Addendum #1

**Peoples Regional Opportunity Program
Phase III Scattered Site Affordable Housing
Anderson & Cumberland Streets, Portland, Maine 04101
North Street, Westbrook, Maine 04101**

January 28, 2005

M1.1

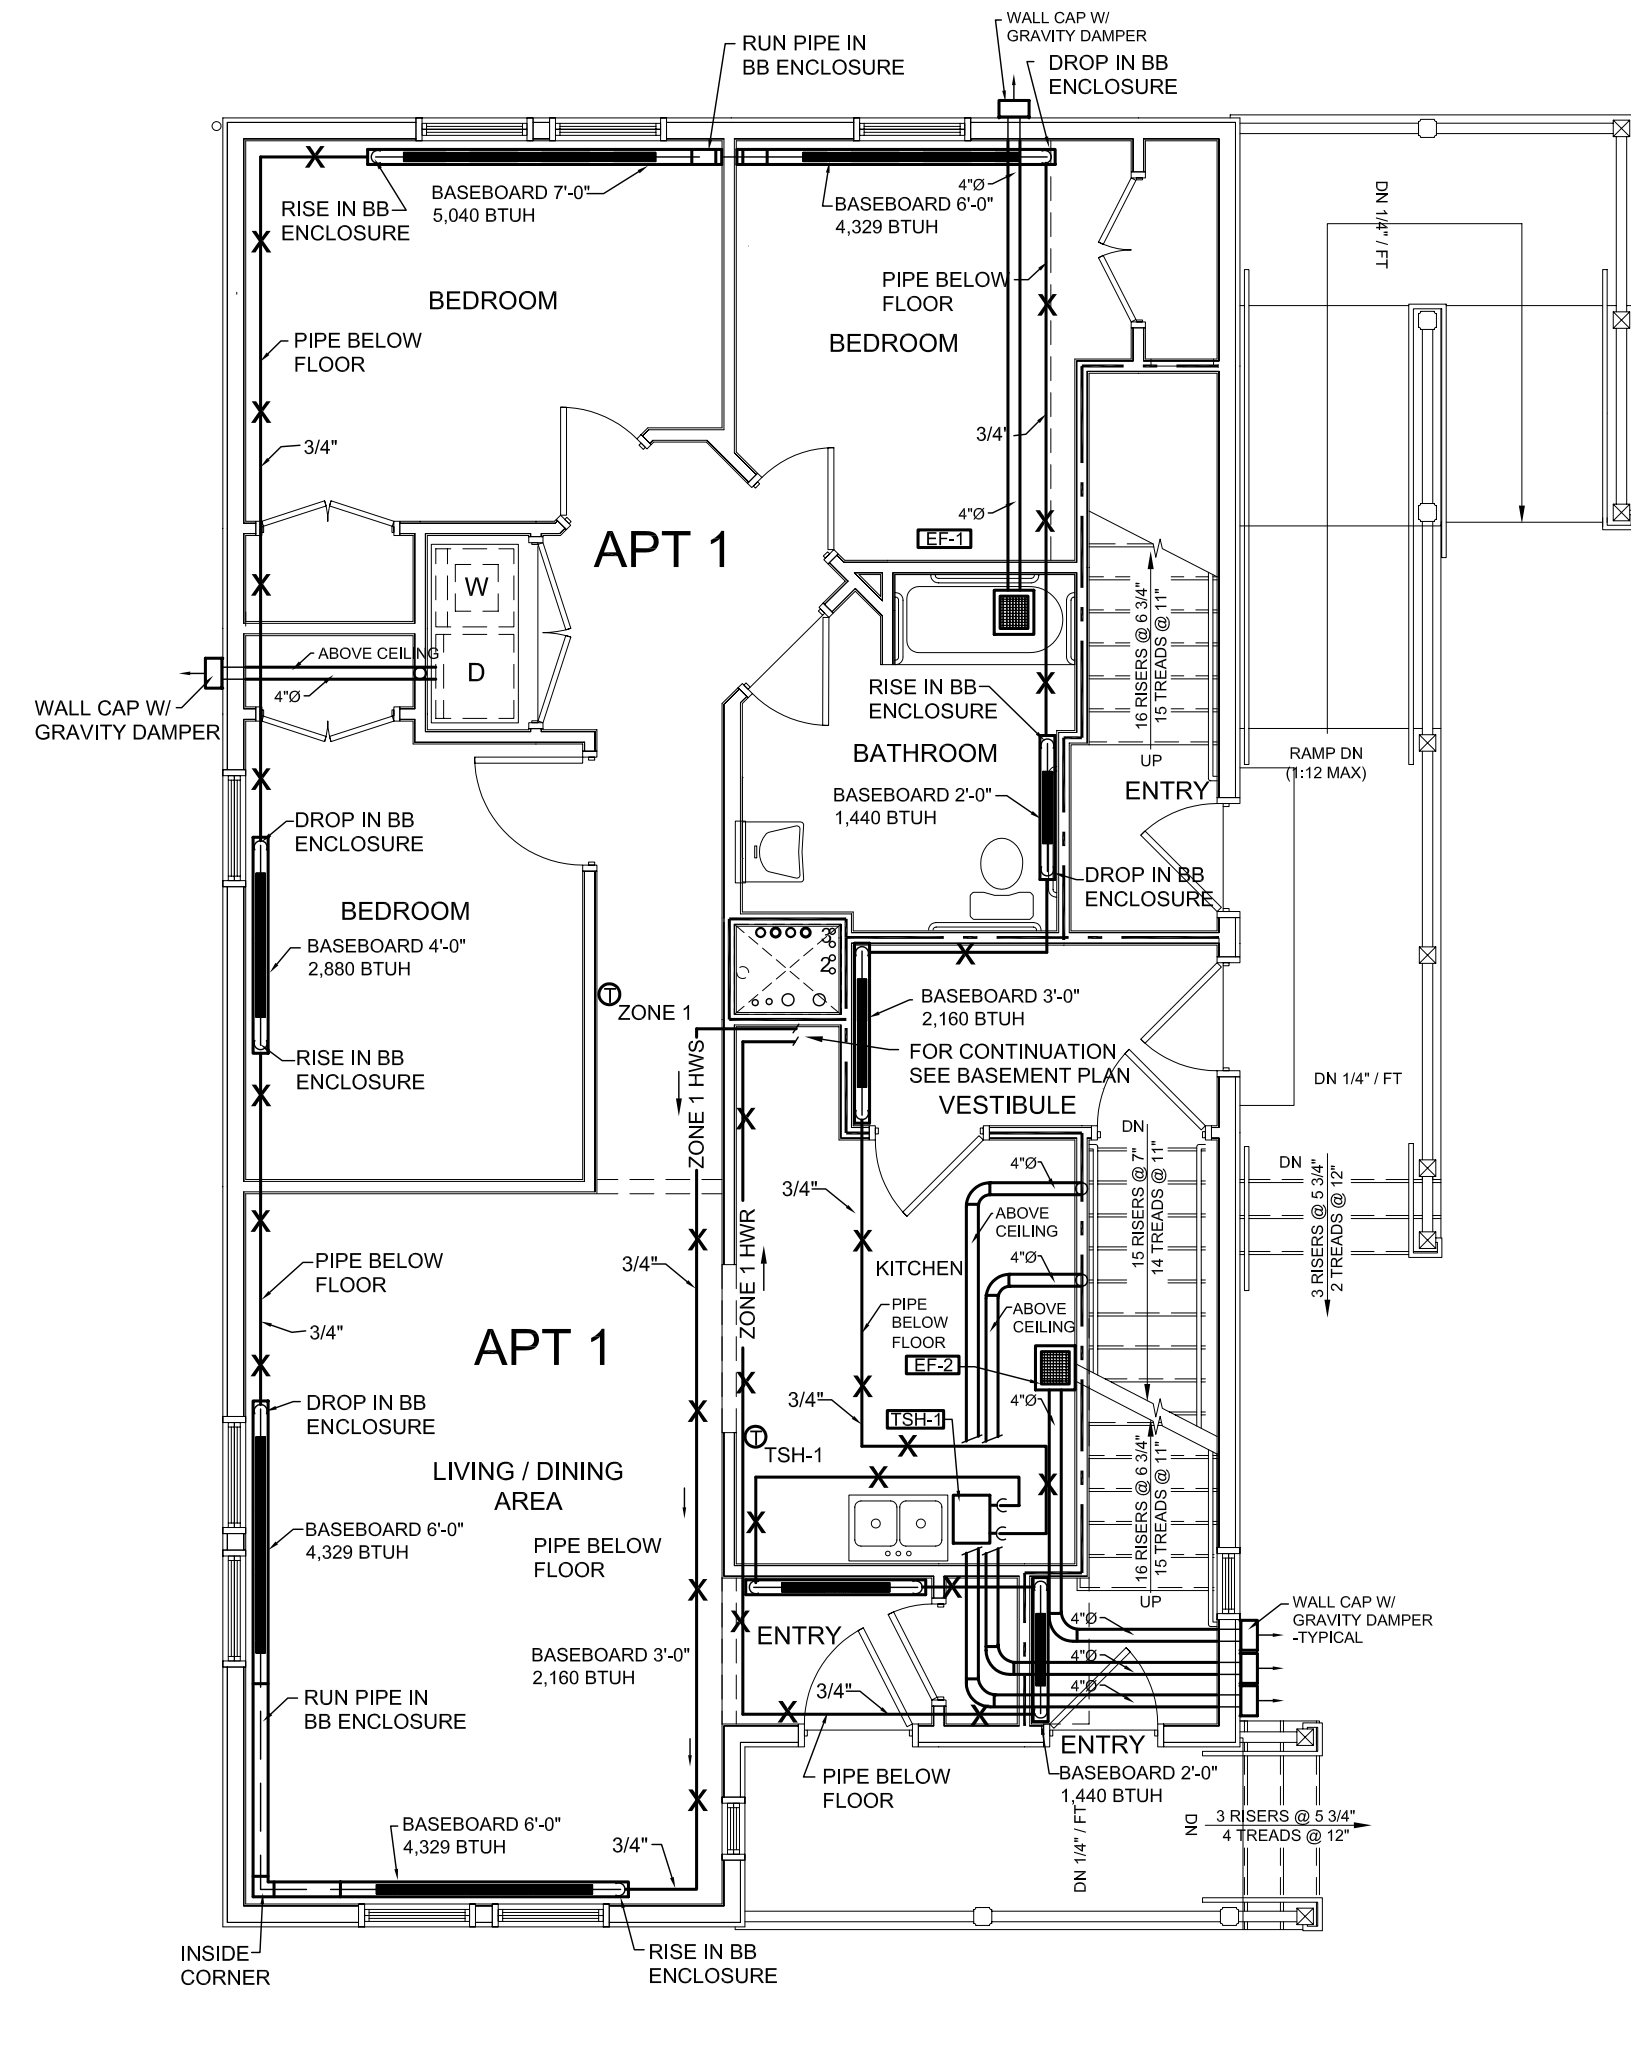
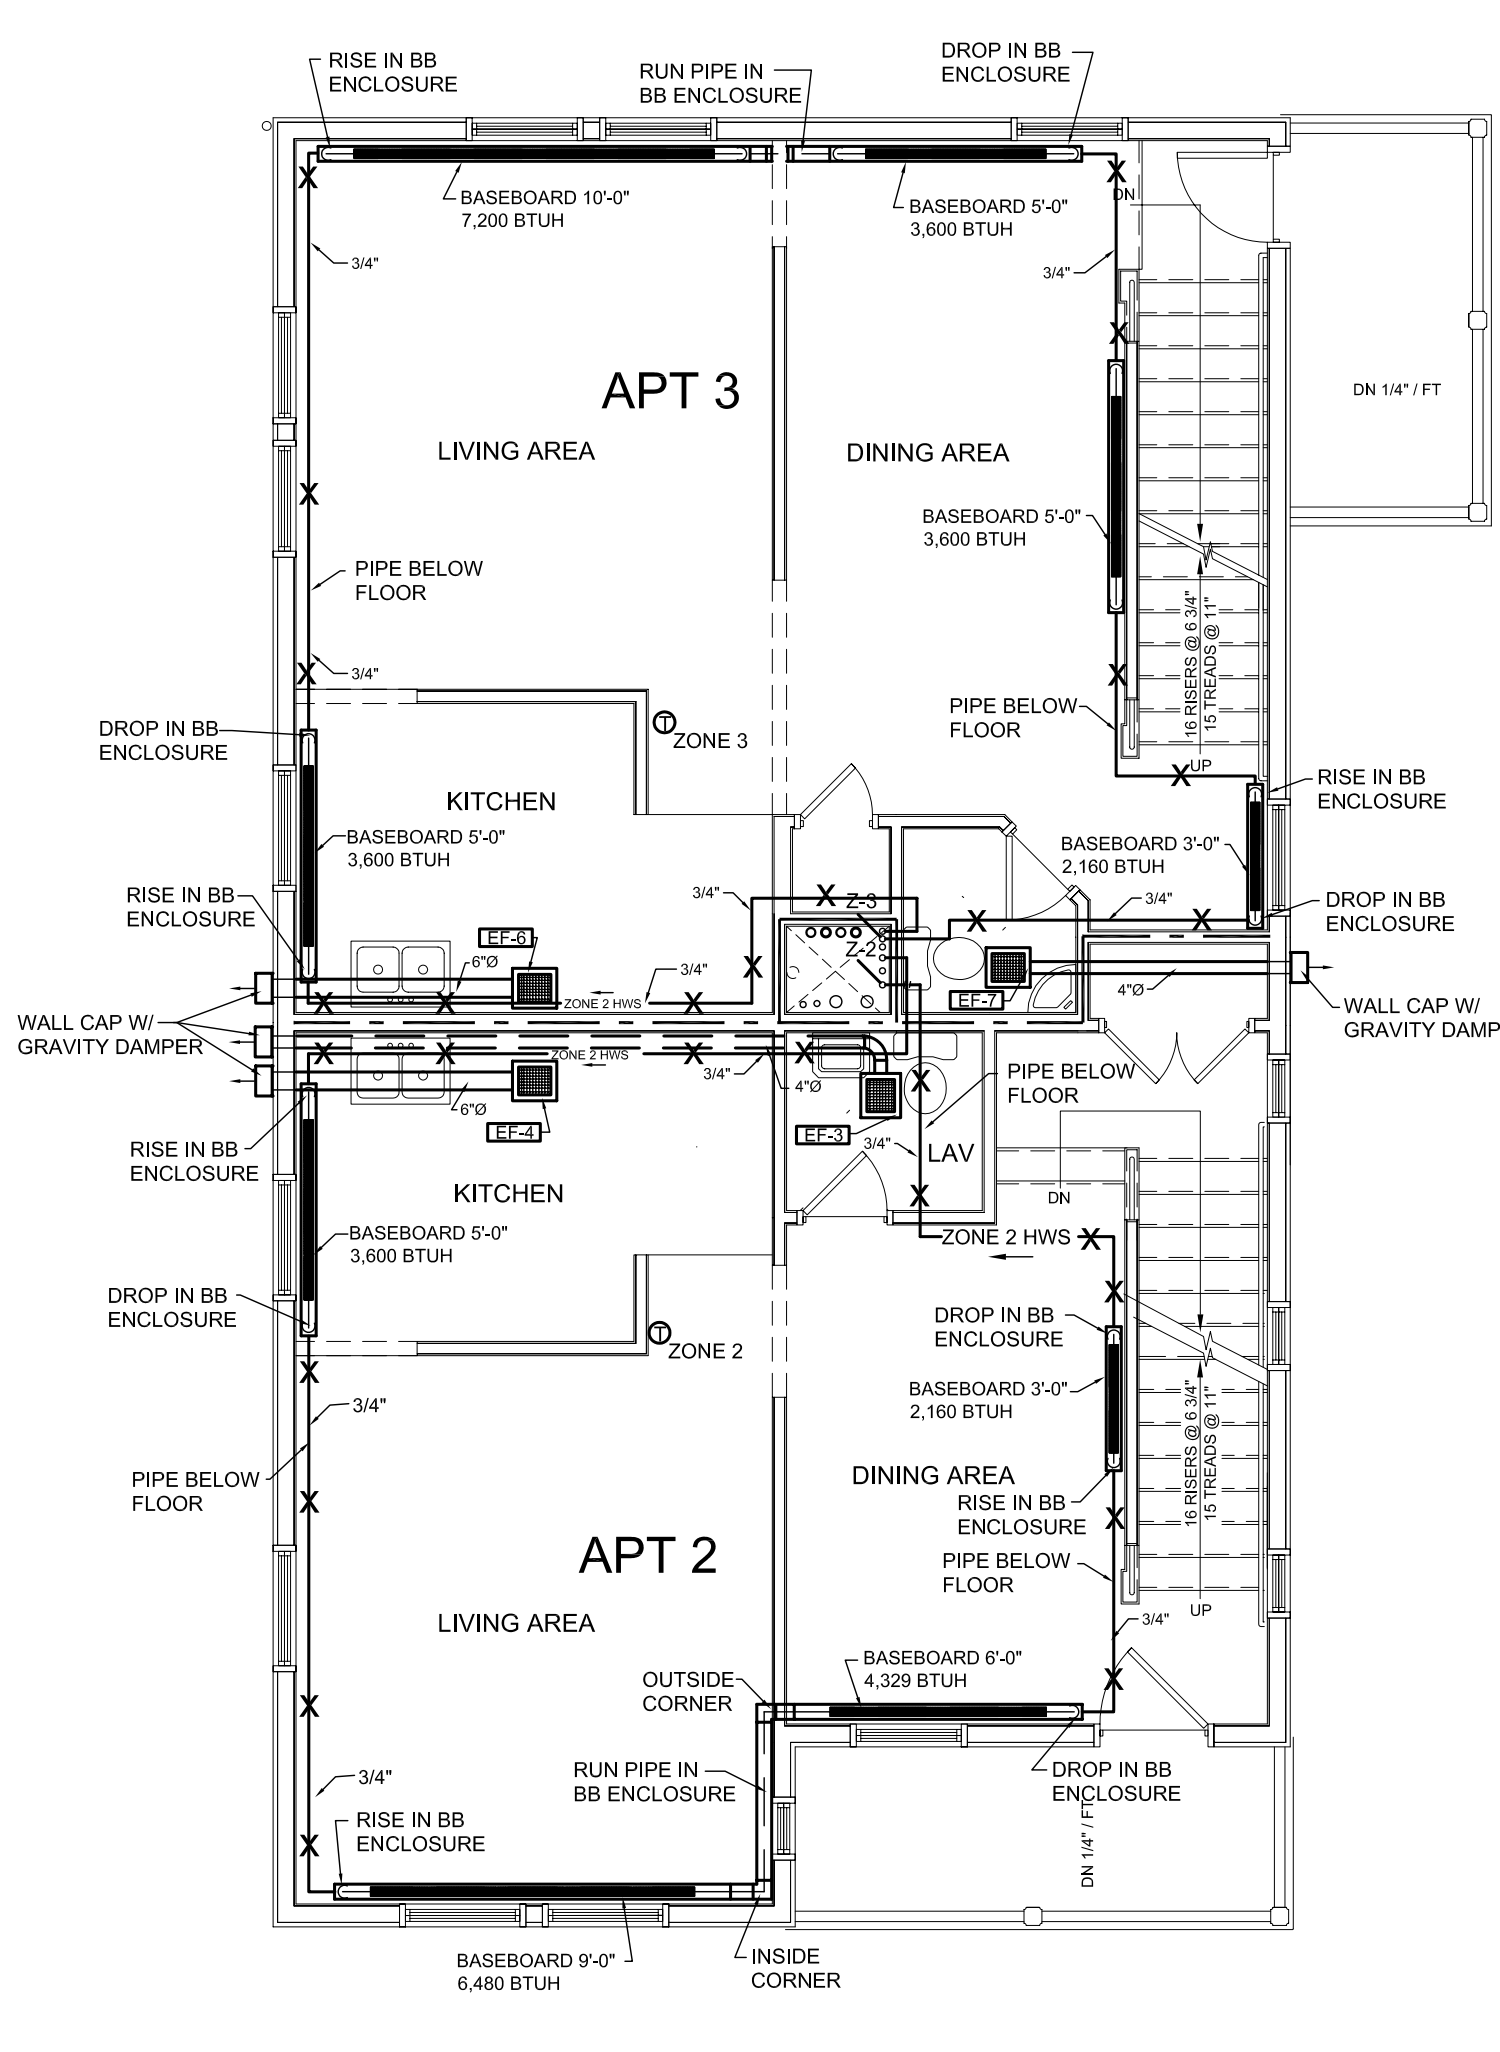
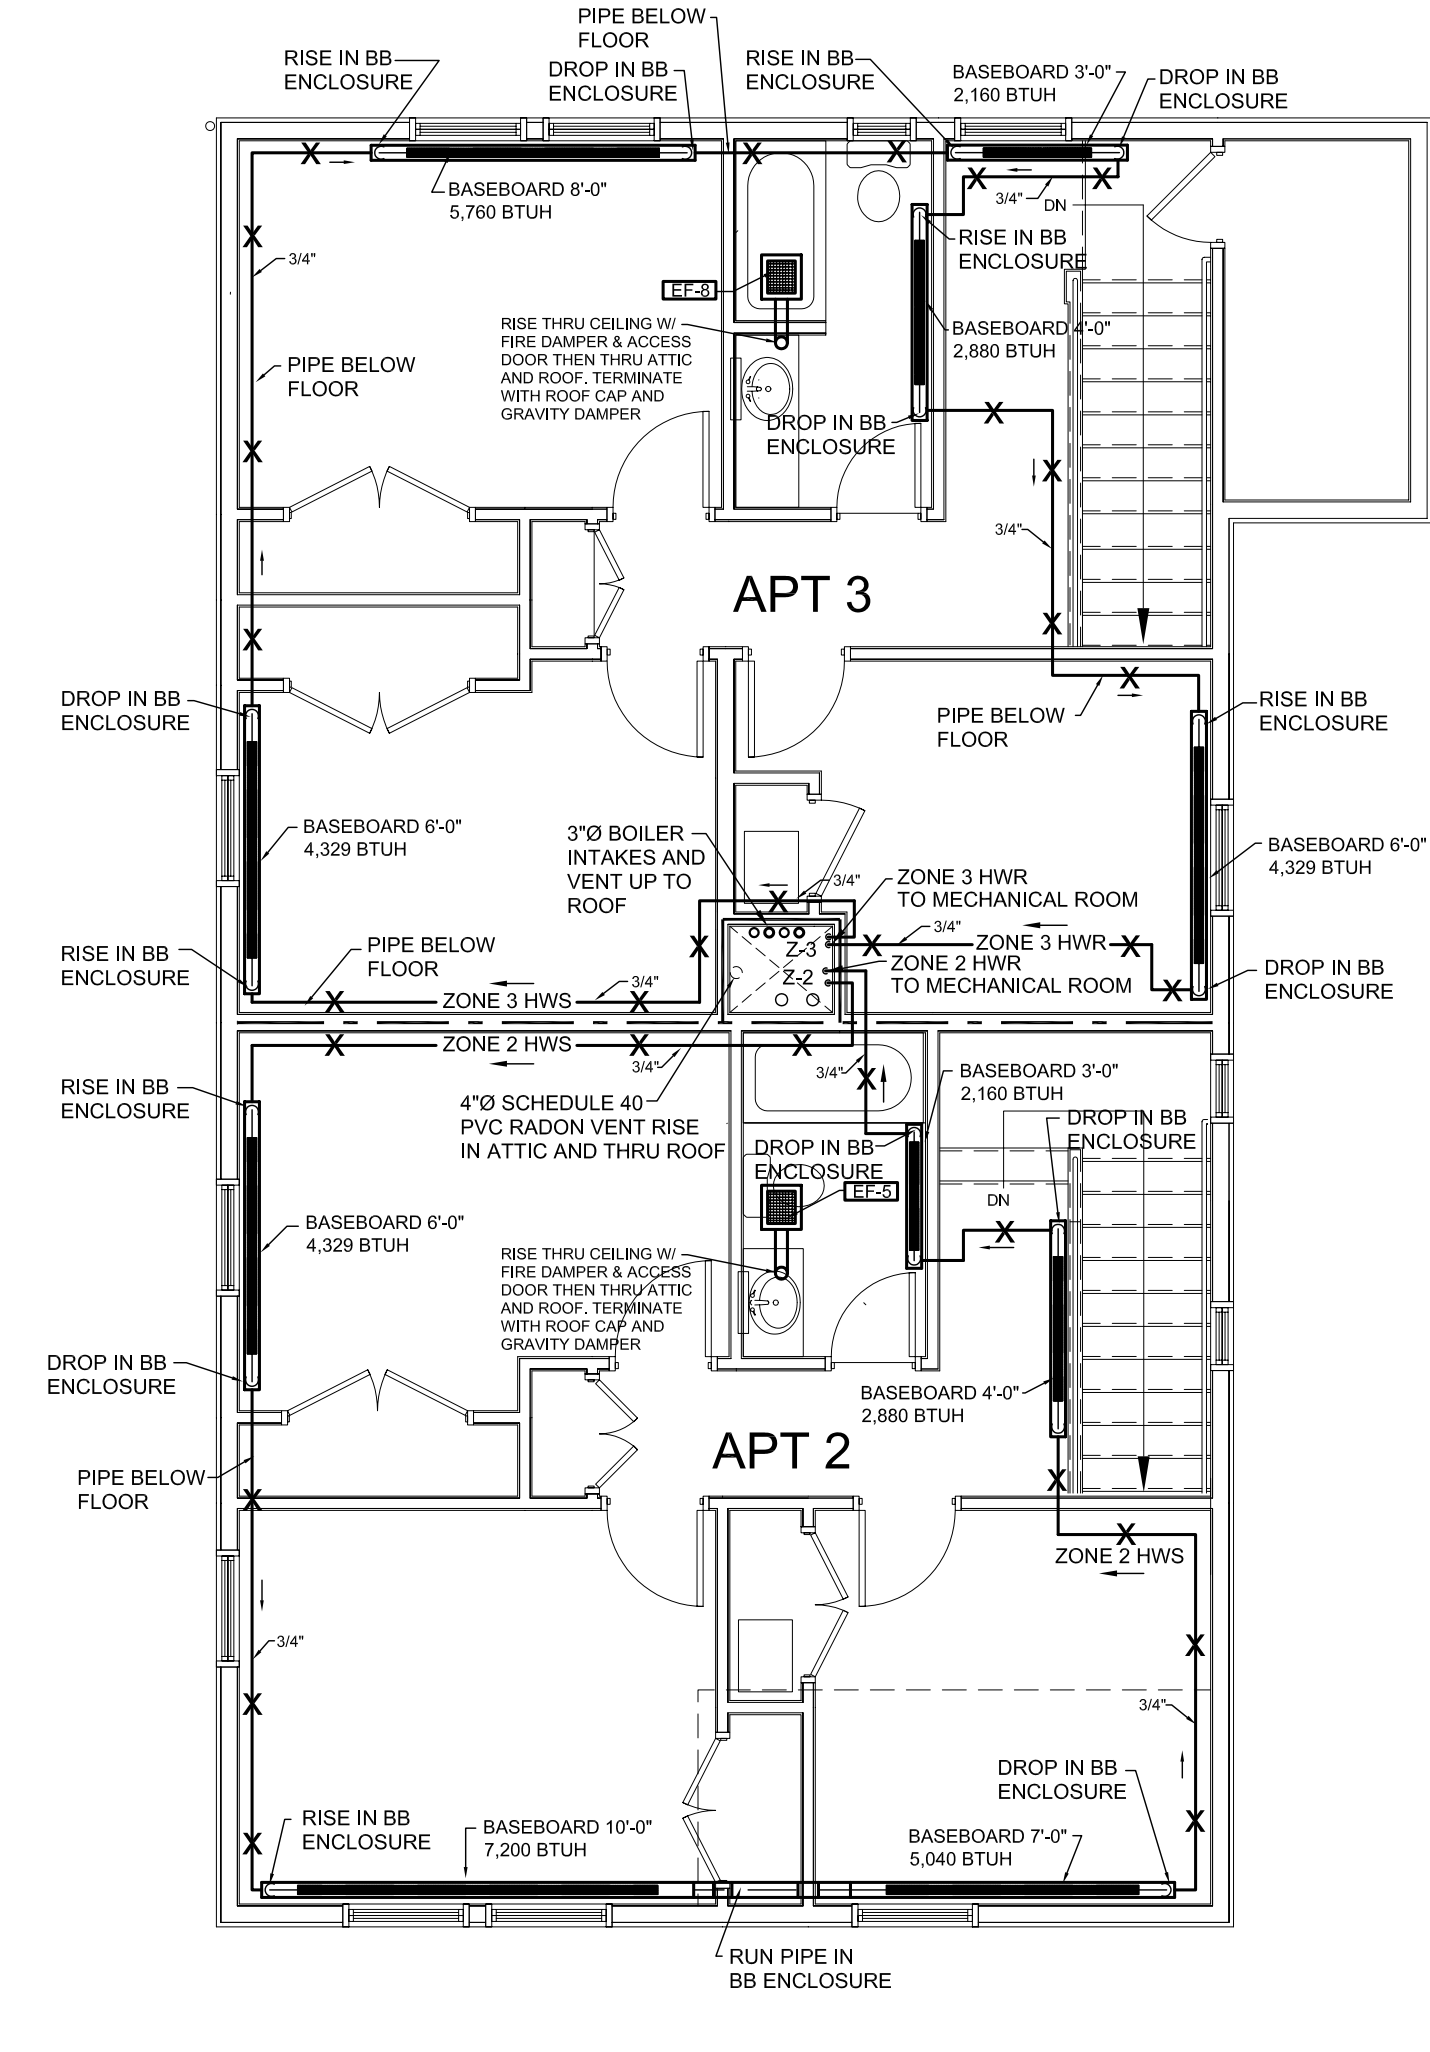
- 1-1 Drawing C6 (Portland, all sites), dated 1/14/05
- 1-2 Drawing C3.0 (Westbrook, all sites) , dated 1/14/05
- 1-3 Drawing M1.1 (Portland Anderson 2), dated 1/25/05
- 1-4 Drawing M1.2 (Portland Anderson 2), dated 1/25/05
- 1-5 Drawing M1.1 (Portland Anderson 3), dated 1/25/05
- 1-6 Drawing M1.2 (Portland Anderson 3), dated 1/25/05
- 1-7 Drawing M1.1 (Portland Anderson 2), dated 1/14/05
- 1-8 SkC-1, dated 1/28/05
- 1-9 SkC-2, dated 1/28/05
- 1-10 SkC-3, dated 1/28/05
- 1-11 SkC-4, dated 1/28/05
- 1-12 SkA-1, dated 1/28/05
- 1-13 SkA-2, dated 1/28/05
- 1-14 SkA-3, dated 1/28/05
- 1-15 SkA-4, dated 1/28/05
